December 8, 2022

**Project Location: Arby's Site Development Plan @ South Academy Highlands
4456 Venetucci Boulevard
Colorado Springs, CO 80906**

This letter is in response to the comments received August 12, 2022 regarding the Arby's Site Development Plan application submitted on July 21, 2022.

EL	DC	BS
DESIGN	DRAWN	CHKD
SCALE:	1" = 20'	
JOB No.:	011098-01-001	
DATE:	11/18/2022	
SHEET	C-16

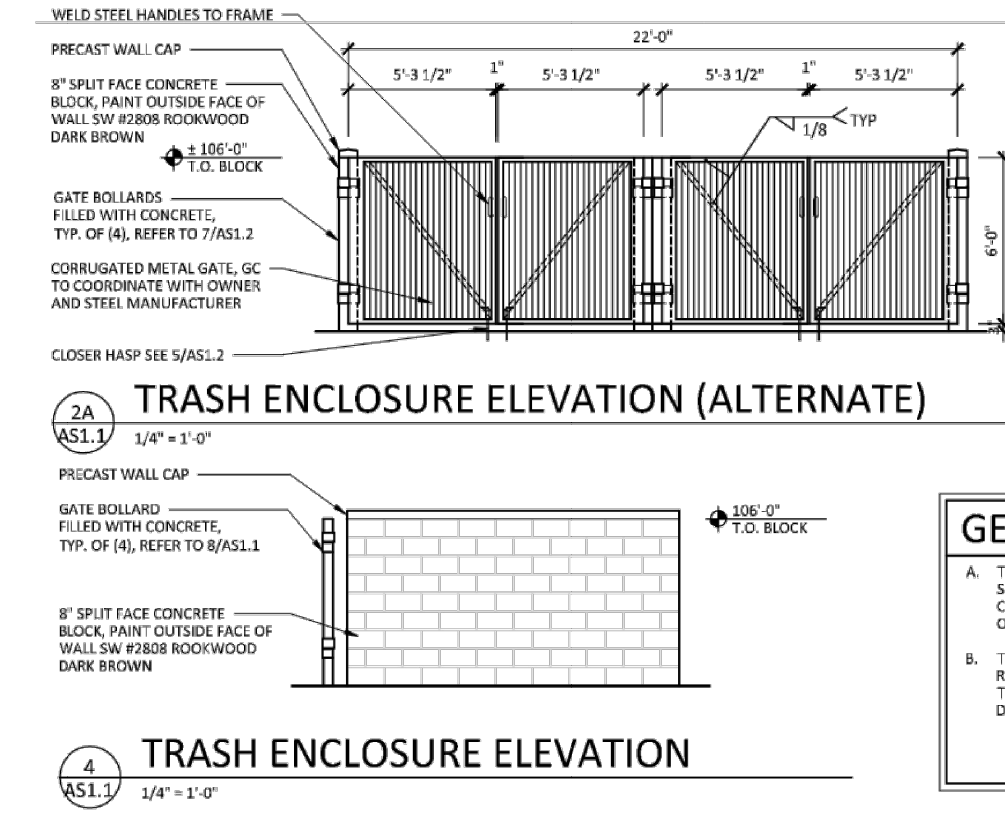
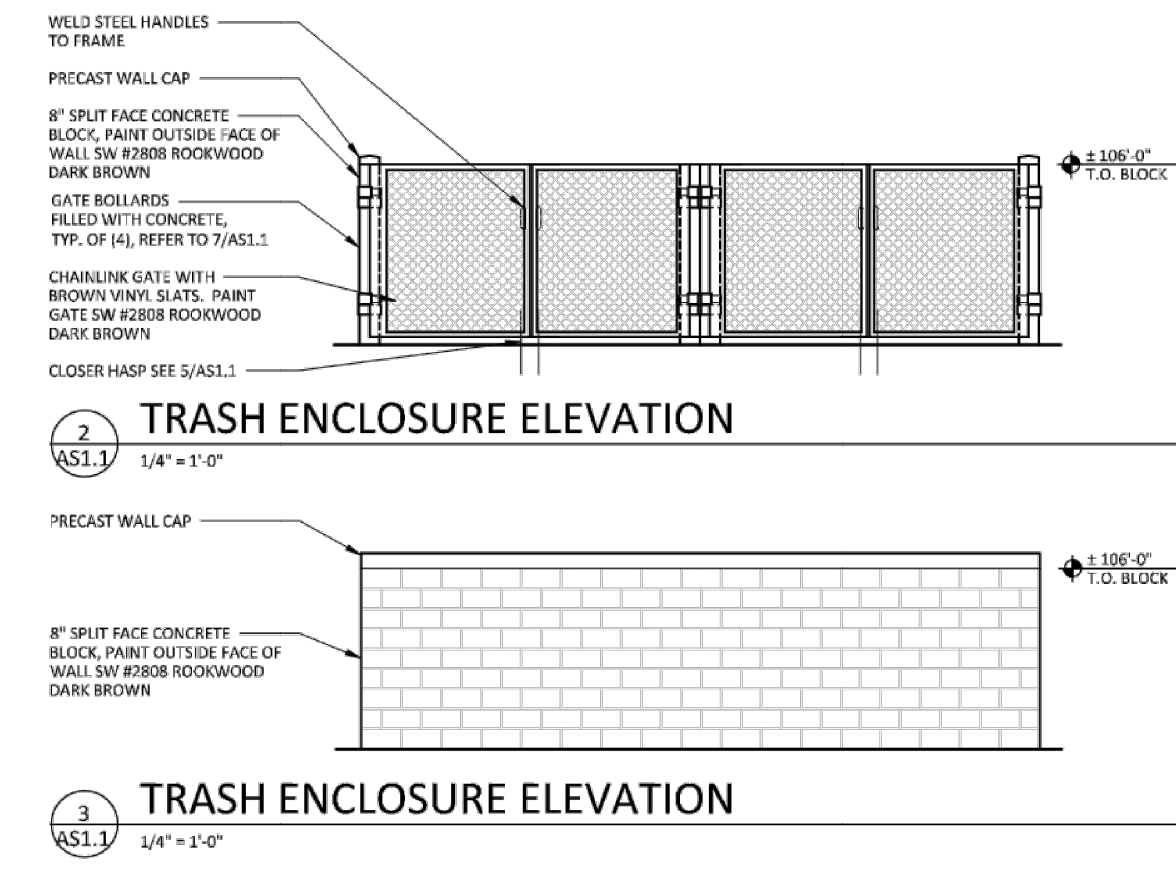
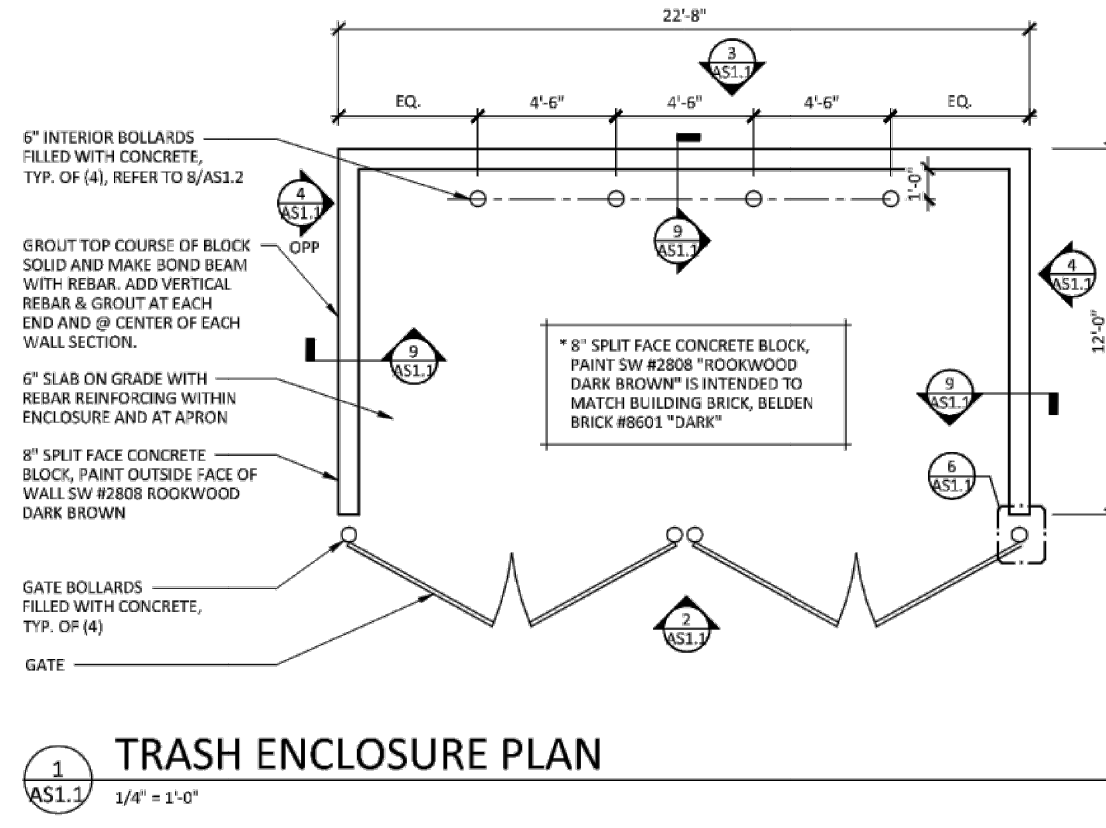
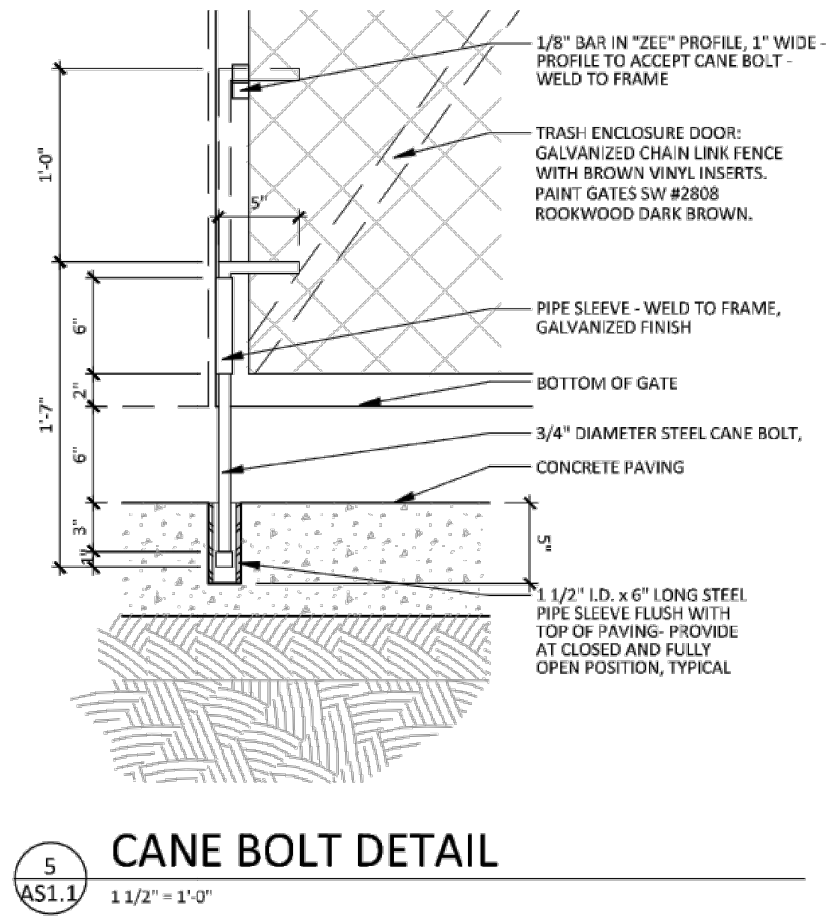
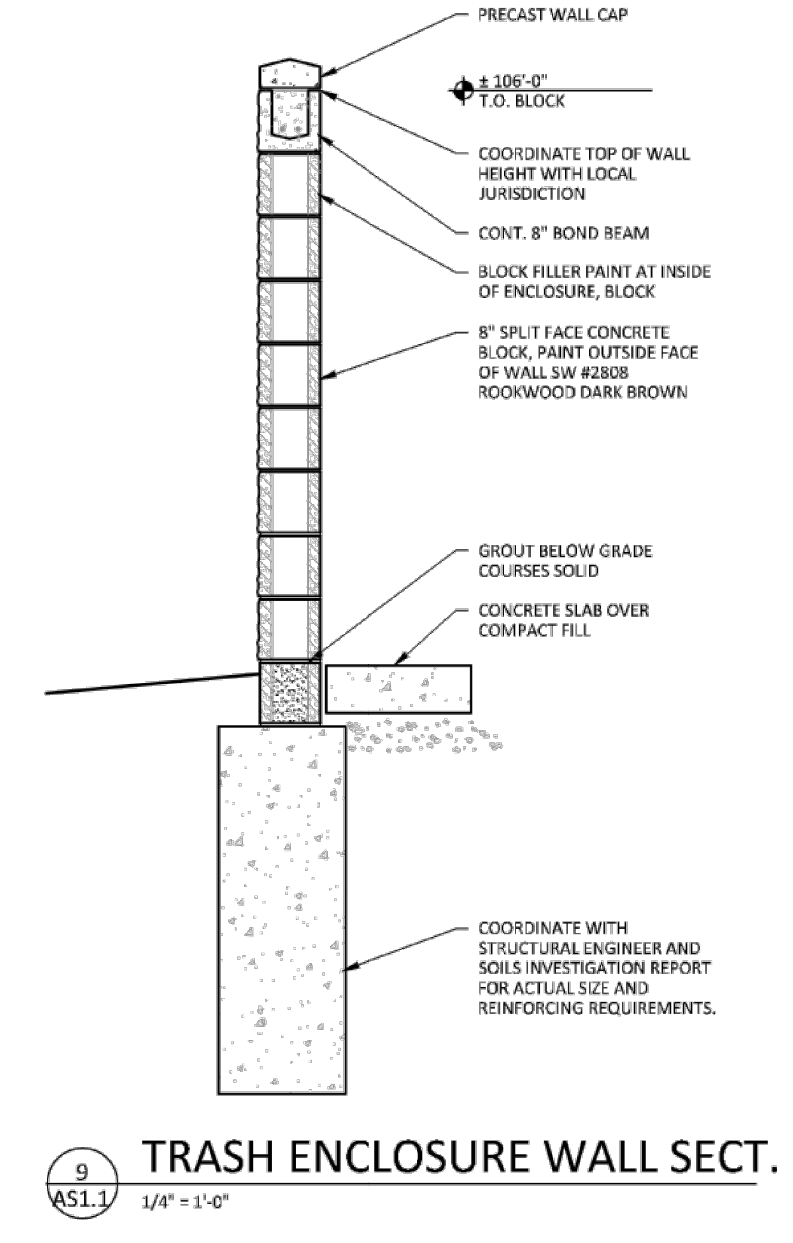
11. Please include the height and screening material of the trash enclosure. Please note trash enclosures exceeding 6 feet in height require a building permit and must meet setbacks.

Response: The height and screening material of the trash enclosure has been added to the site plan. Please see Site Plan Design Notes, note 15 on Sheet C-7. See the Trash Enclosure Details on sheet C-16, Construction Details.
